Jeanie Bourke - Re: FW: FW: 55 Exeter Street Ramp info

57-E-15

To: Jeanie Bourke (jmb@portlandmaine.gov)
Cc: 'Carol Potter'; 'dimatteocms@yahoo.com'
Subject: 55 Exeter Street Ramp info

BEAM POST CONNECTION DETAIL

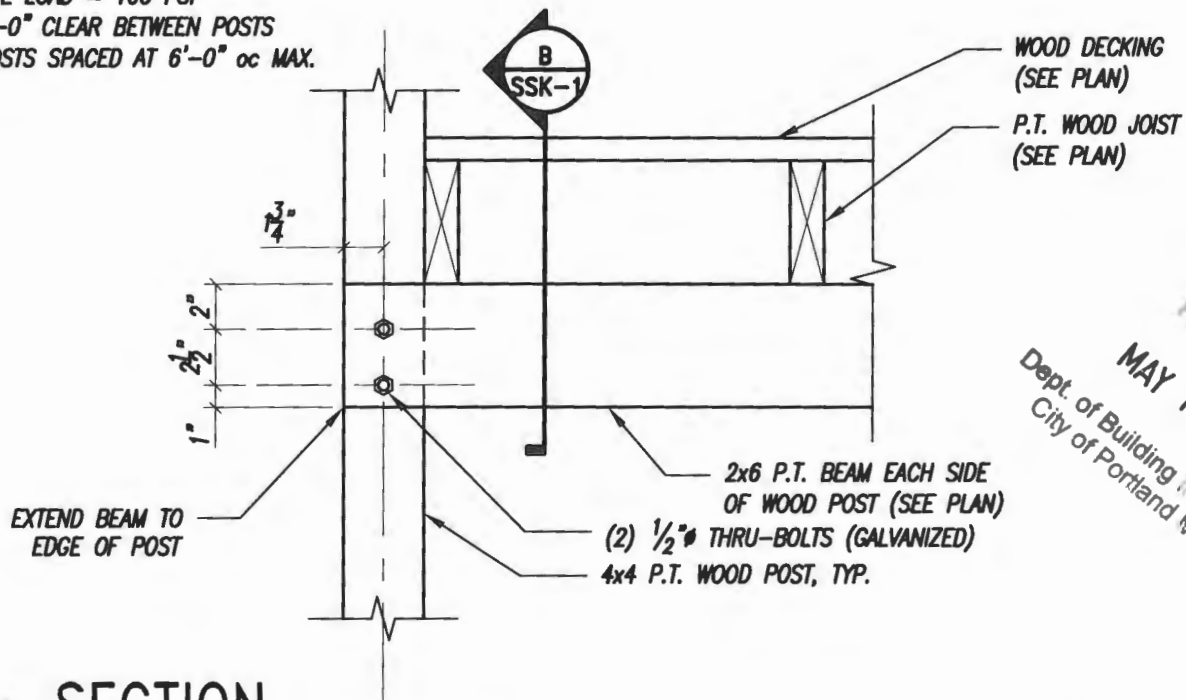
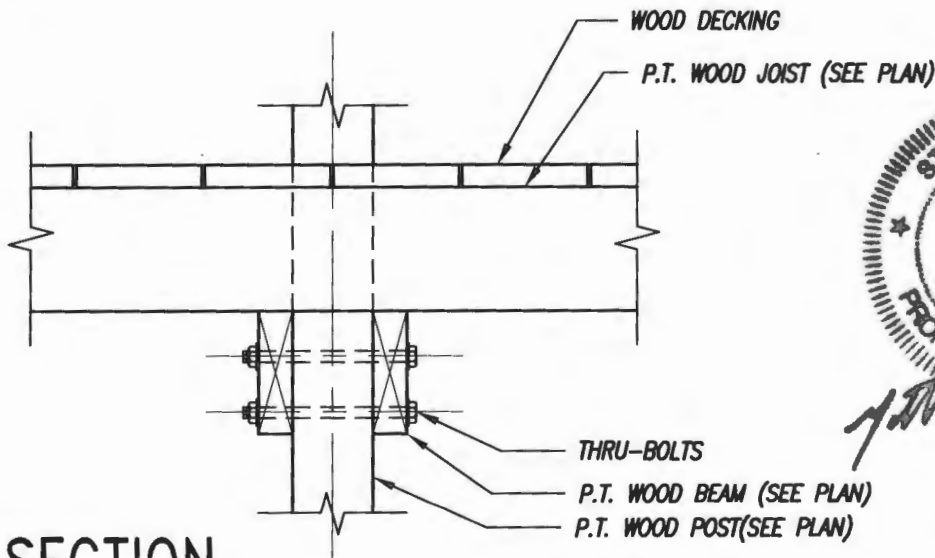
Thanks Kristi,
This satisfies the attachment detail to the posts, can you please also confirm that he approved the framing design for the landing. This is slightly different from the ramp framing in that the joists are 2' O.C. and there is no beam on either of the carrying ends.

Here are my remaining comments. There is one beam size that was a little light at the upper landing, and one connection that could not be made with through bolts. The rest checks out.

A9 RAMP FRAMING PLAN
1/4" = 1'-0"

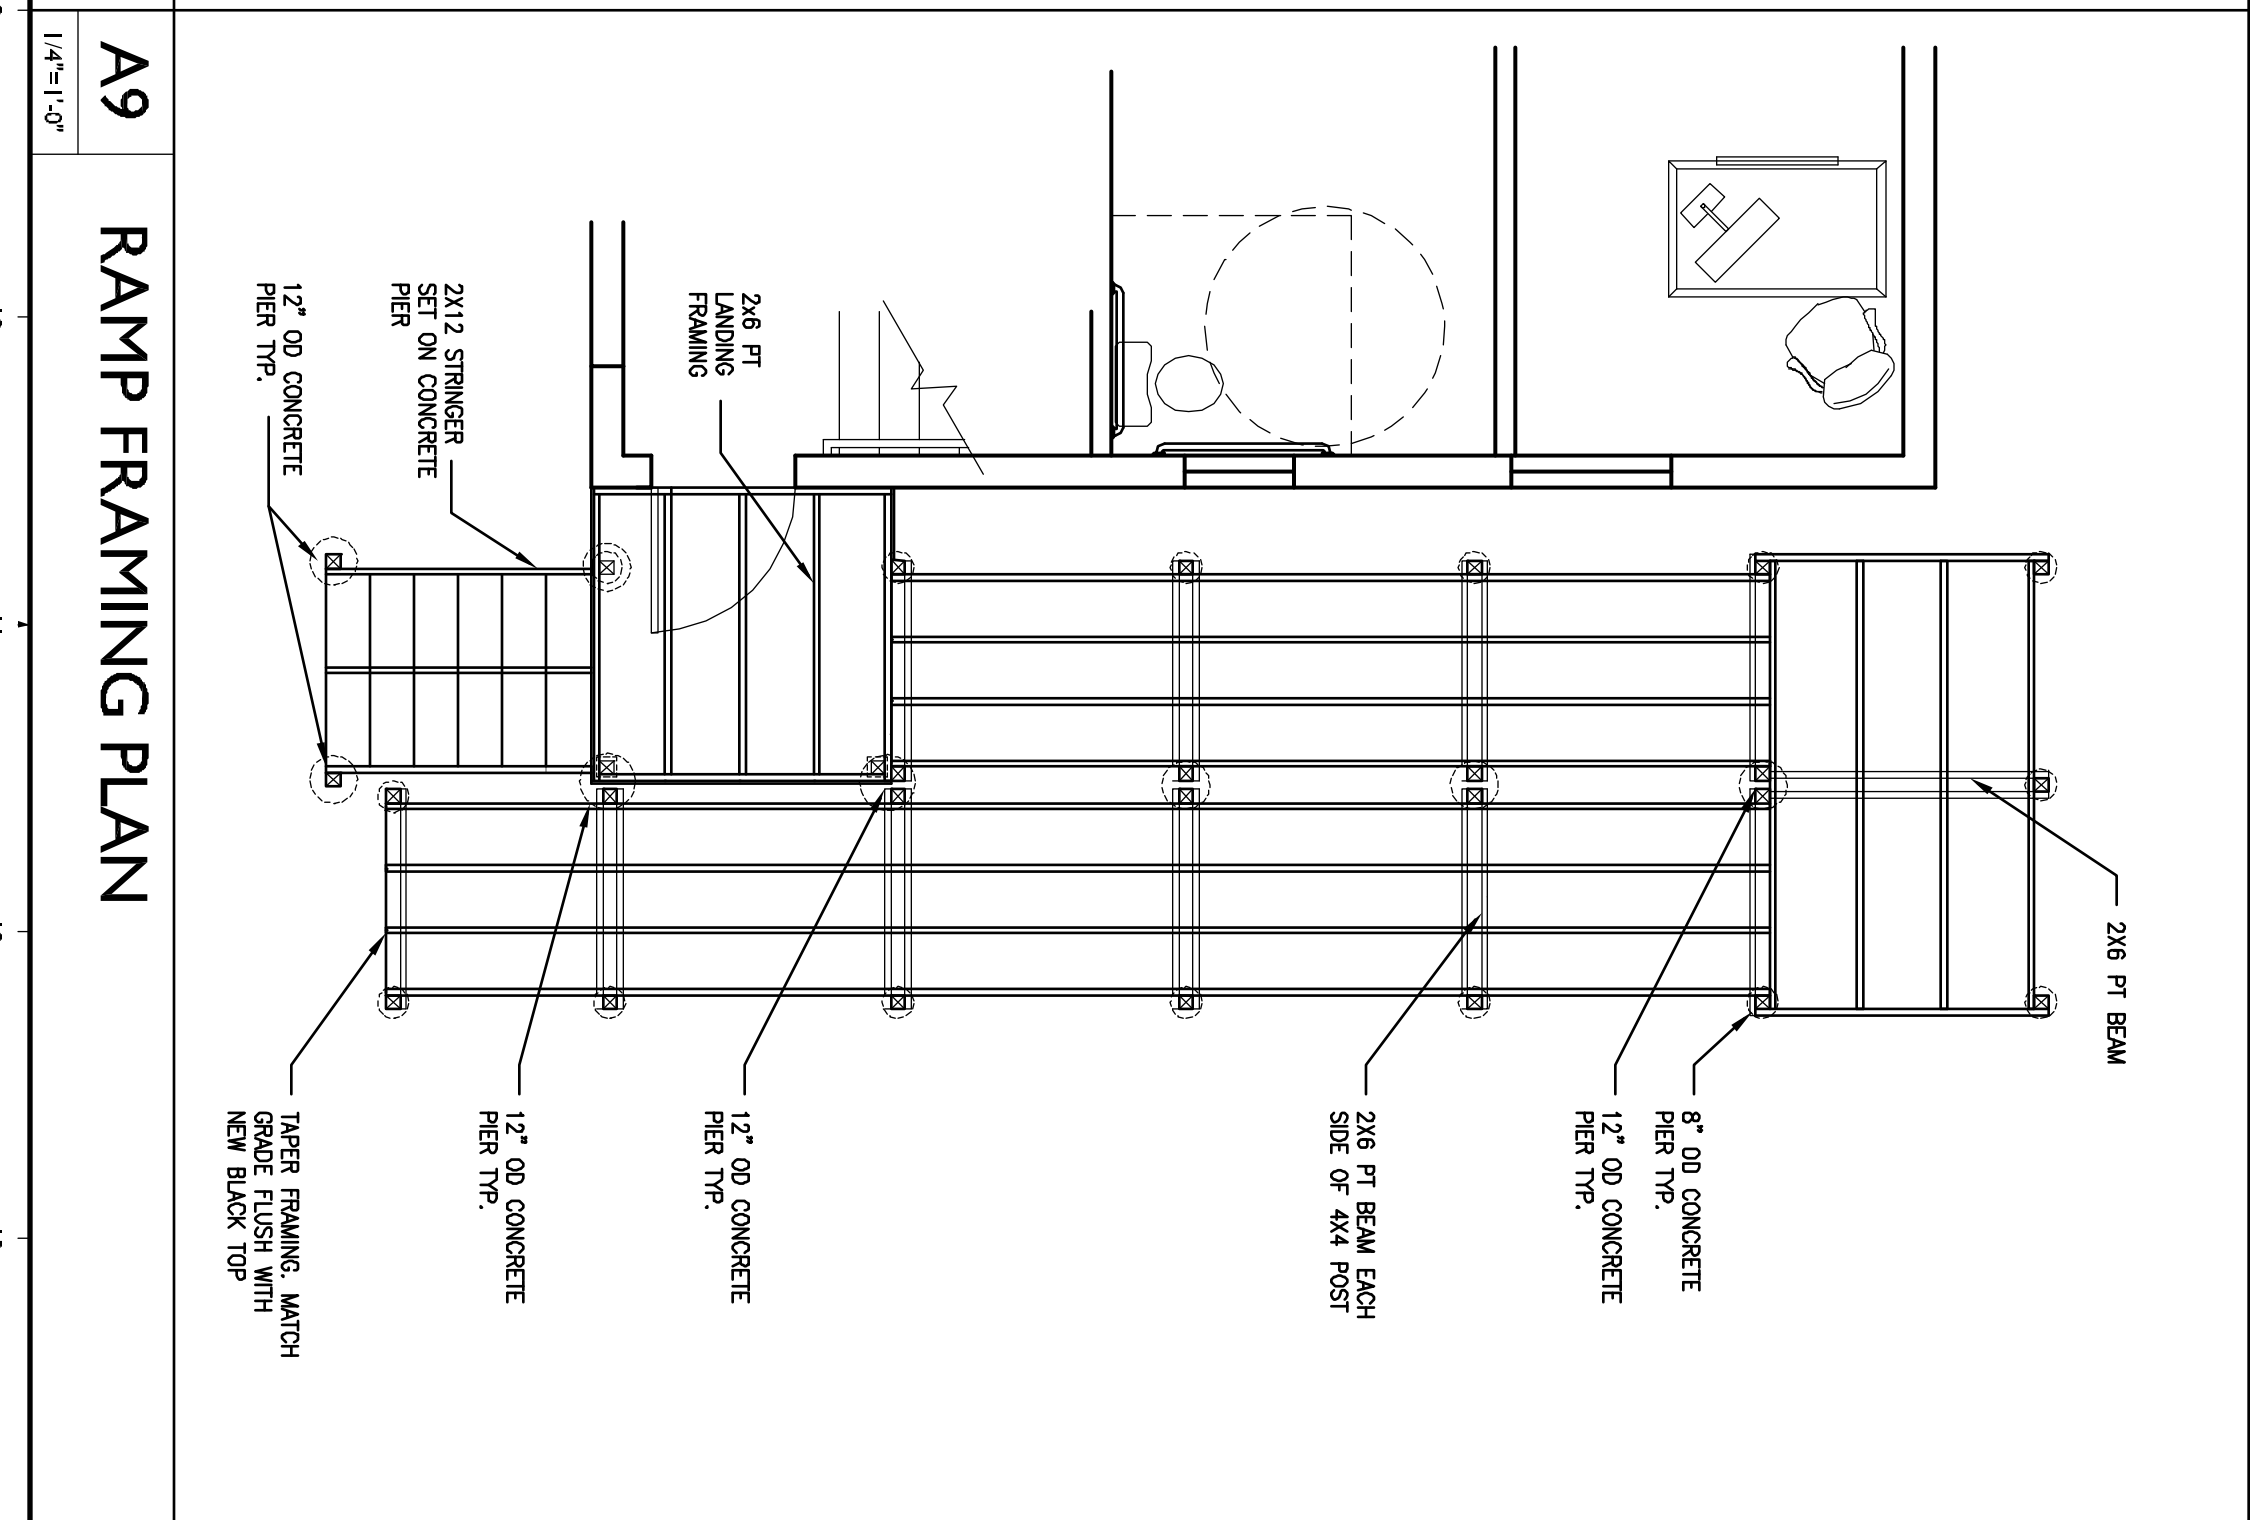
Thanks for the response and detail...I'm a bit suspect of the outer bearing rim on the ramp landing being a single 2x6, but it appears Matt has approved the overall construction details.
